**APPLICATION BY KEADBY NEXT GENERATION LIMITED FOR AN ORDER GRANTING DEVELOPMENT CONSENT FOR THE KEADBY NEXT GENERATION POWER STATION PROJECT**

**SCHEDULE OF AMENDMENTS FOLLOWING S.51 ADVICE**

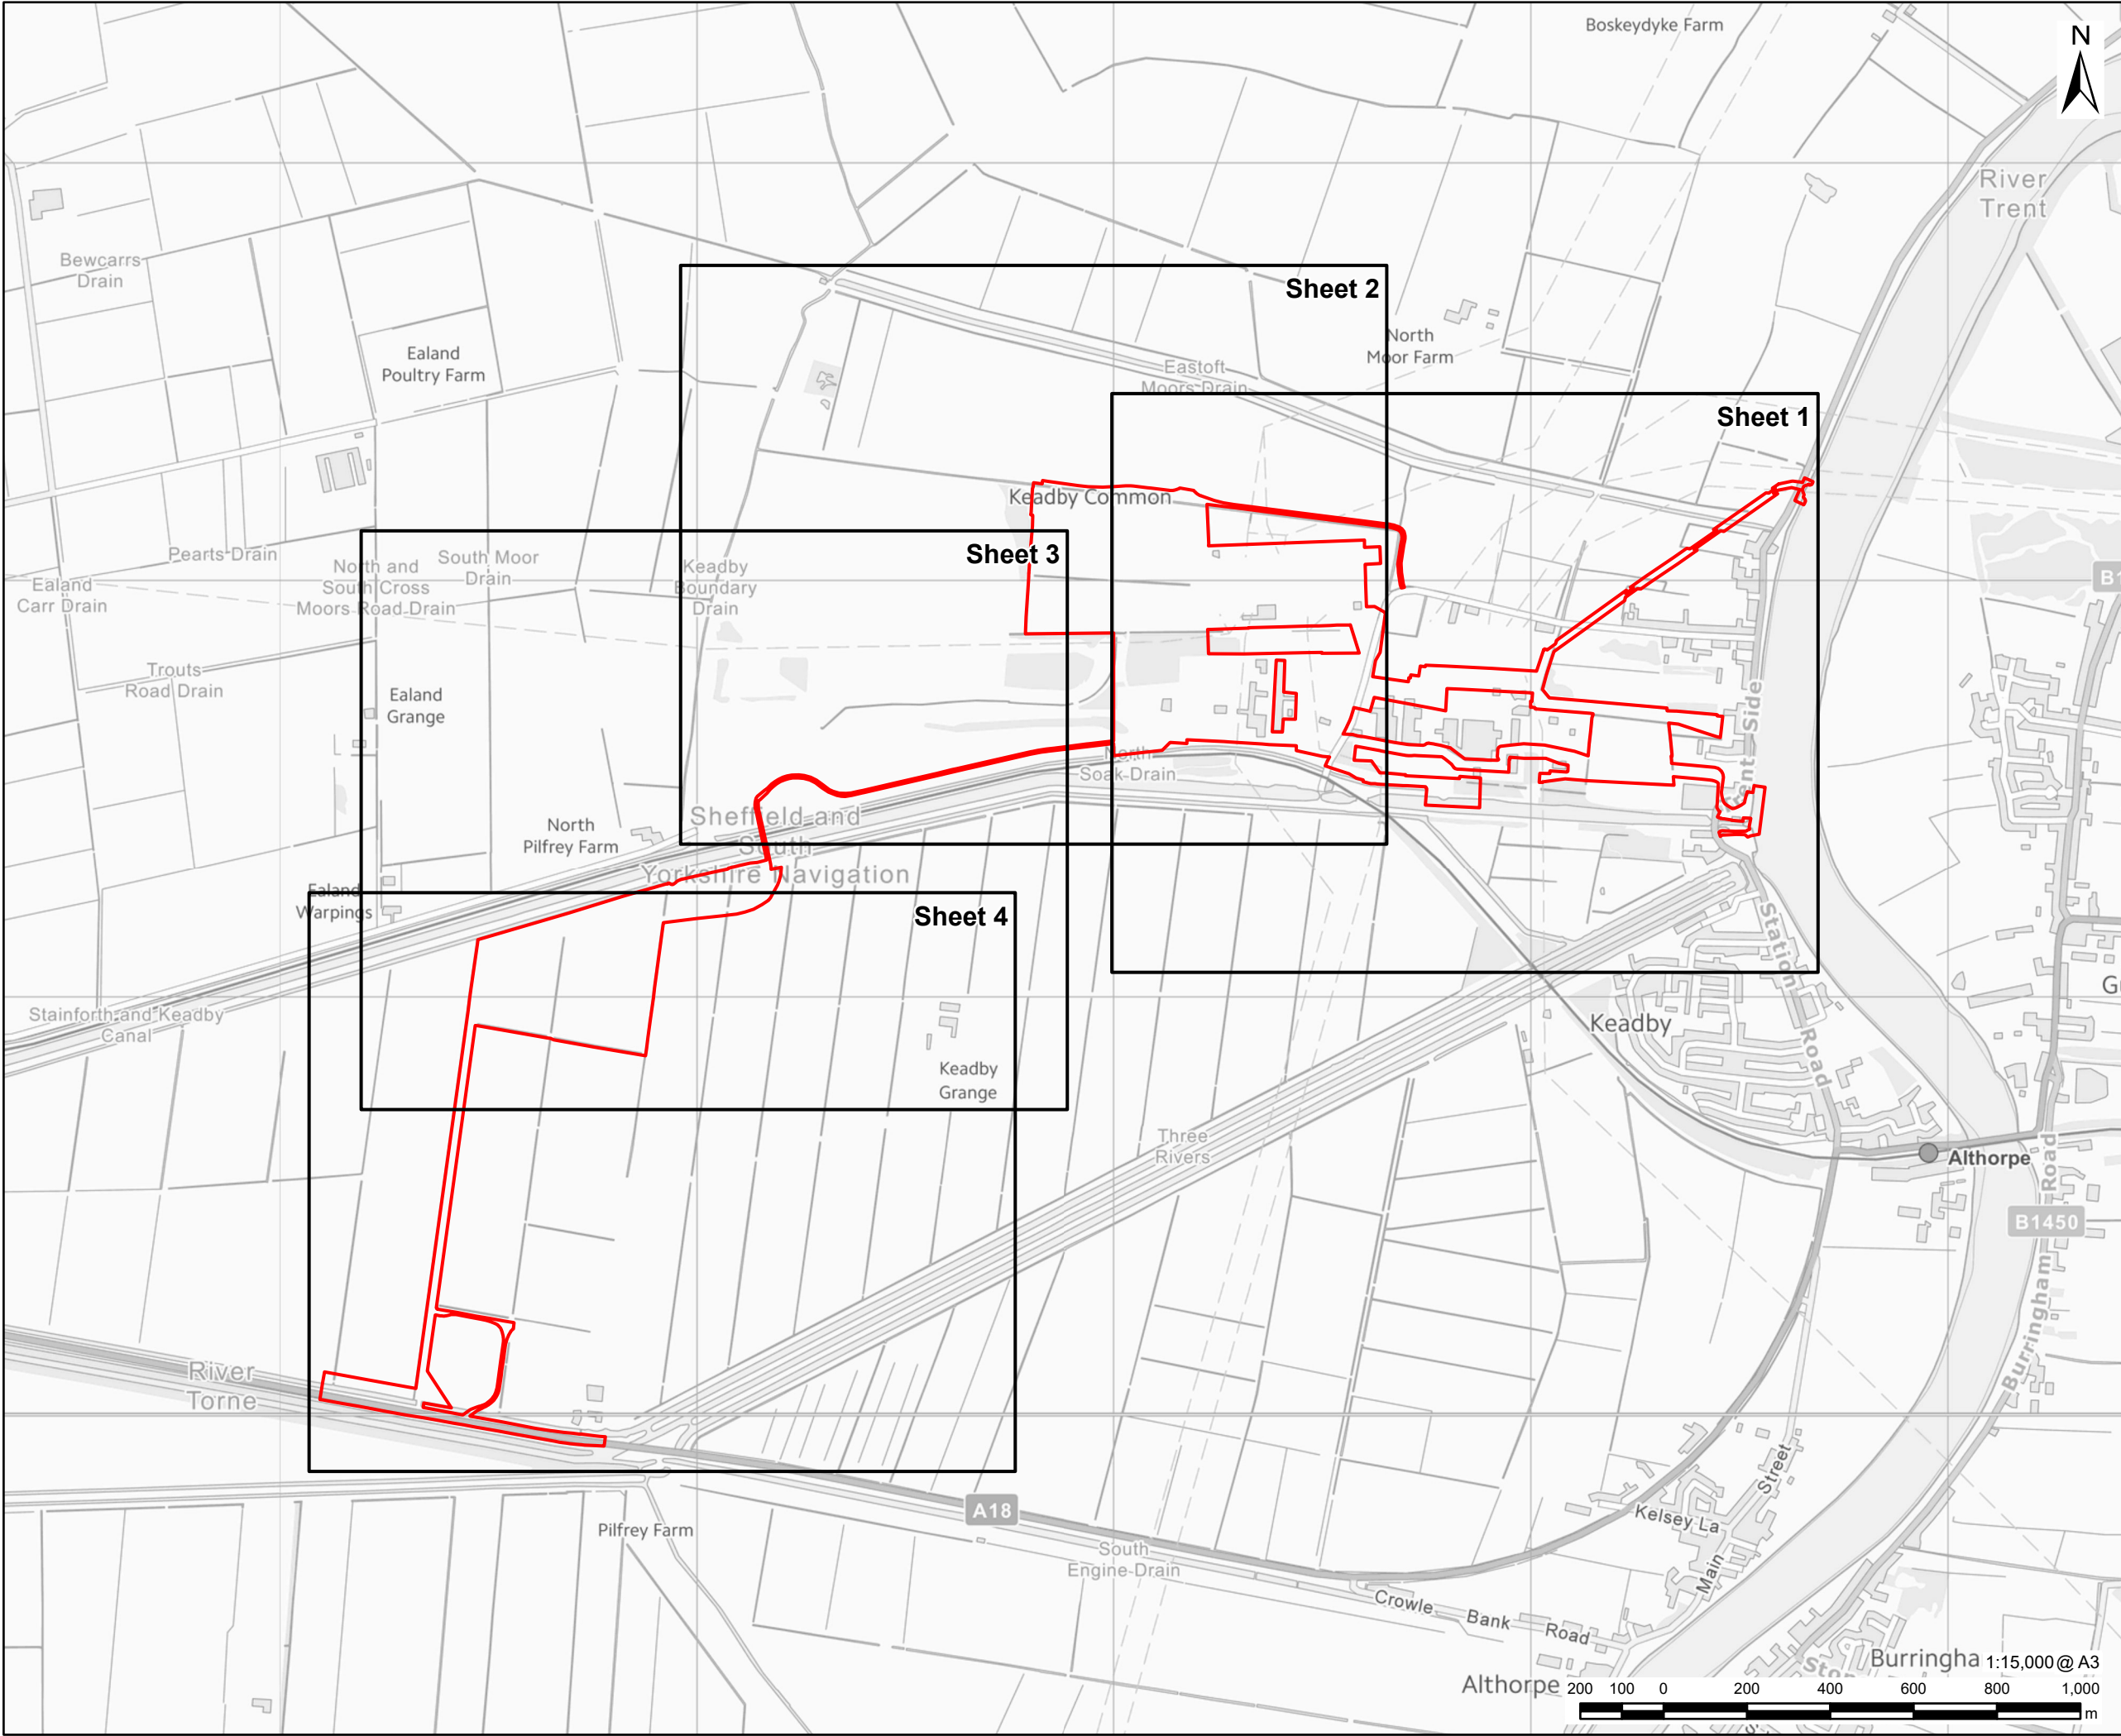
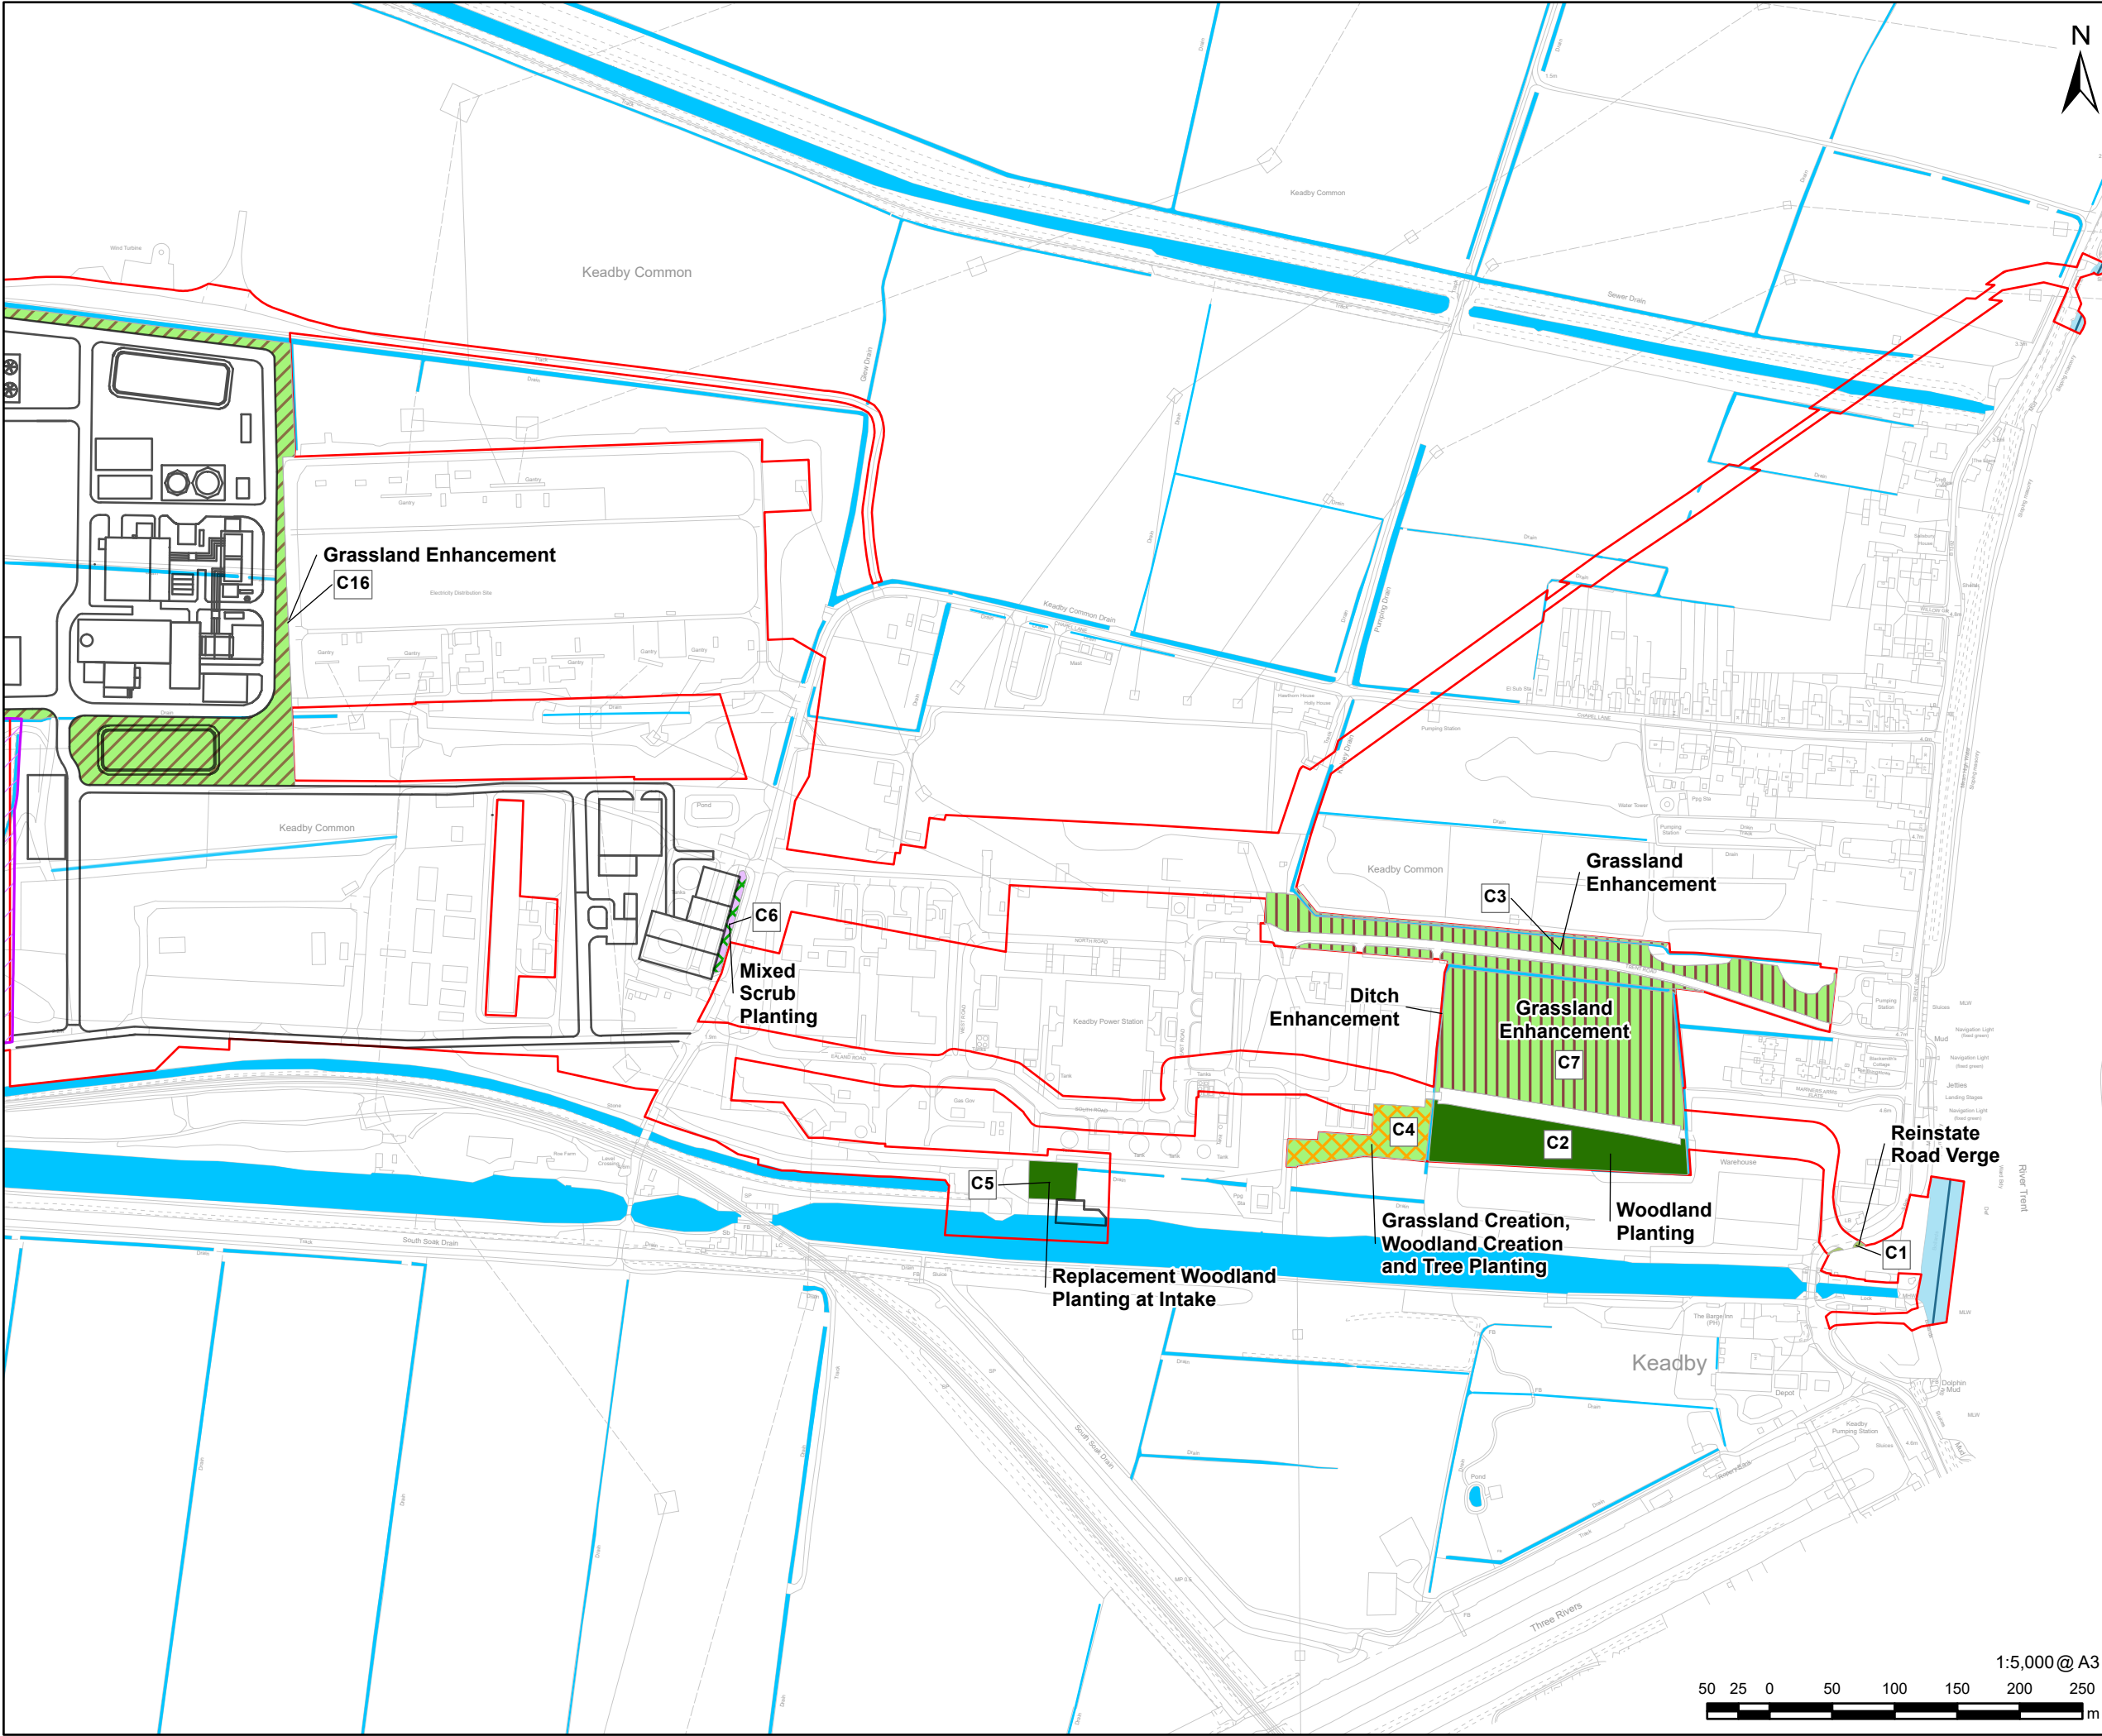
Issue	Detail	Response
Indicative Landscape and Biodiversity Plan (Doc 2.18)	Missing a key plan	Key Plan added – see Indicative Landscape and Biodiversity Plan Rev 1.
Draft Development Consent Order (dDCO) (Doc 3.1)	Query as to why a Deemed Marine Licence (DML) included in K3 but not for KNGPS.	<p>No works are proposed within the marine area, as part of the water discharge corridor that requires a DML to be in place for the purposes of constructing the Proposed Development.</p> <p>As noted in the s.51 letter of 22 September 2025, no river water abstraction option is proposed as part of this Application. The Application includes Work No.6 which is similar in scope to Work No. 5 of the Keadby 3 consent. These works include:</p> <p>i) connection works to an existing pipeline, which will occur on land (the Connection Works),</p> <p>ii) potential upgrades to an existing pipeline and associated structures (the Upgrade Works).</p> <p>Discharge from the existing pipeline would be regulated by the environmental permitting regime, and not the marine licensing regime. Therefore, no marine licence is required in this regard.</p> <p>Since the Connection Works will occur on land, they are not within the ‘marine area’ and therefore do not fall under the MMO's jurisdiction and therefore do not require a marine licence.</p> <p>The Upgrade Works have been included within Schedule 1 of the draft DCO to ensure that the Applicant has the ability to upgrade and replace the outfall structure and connecting pipeline as necessary during the lifetime of the development. These are not works that are required to be undertaken as part of the initial construction stage.</p>
